From: Richard Vickery [REDACTED]
Sent: 19 October 2018 09:42
To: Planning.Responses
Subject: Re: Further Information Required on Your Ref: PP-07360526 Our Ref: R/246/18/HH

For the attention of Sian Eggington R/246/18/HH

West Elevation: Scale 1:100

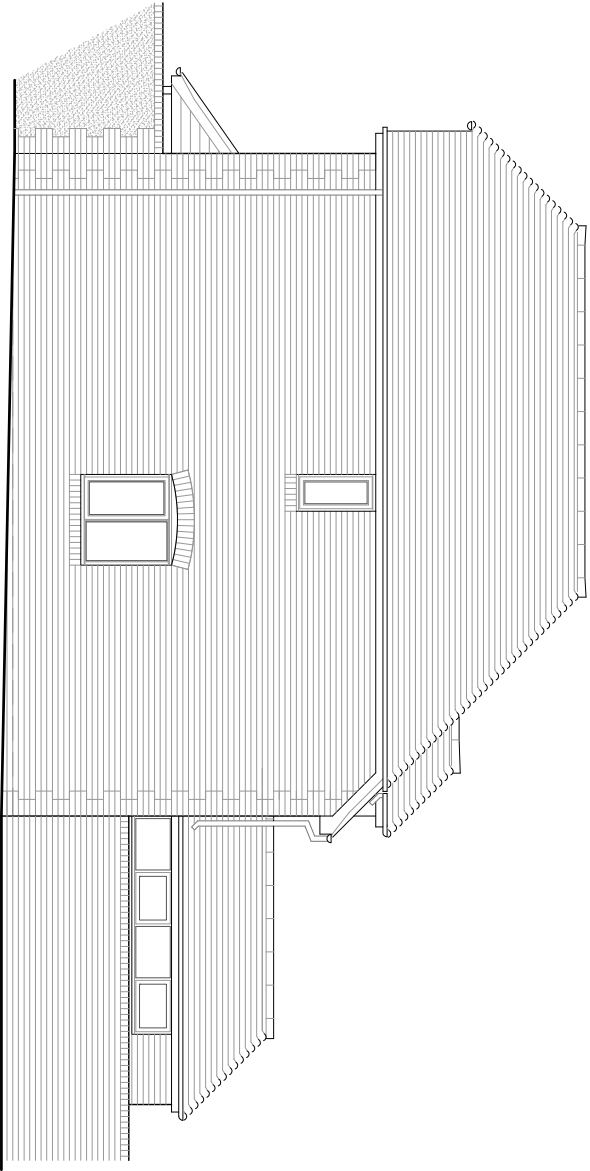
The windows are high level - see west elevation.
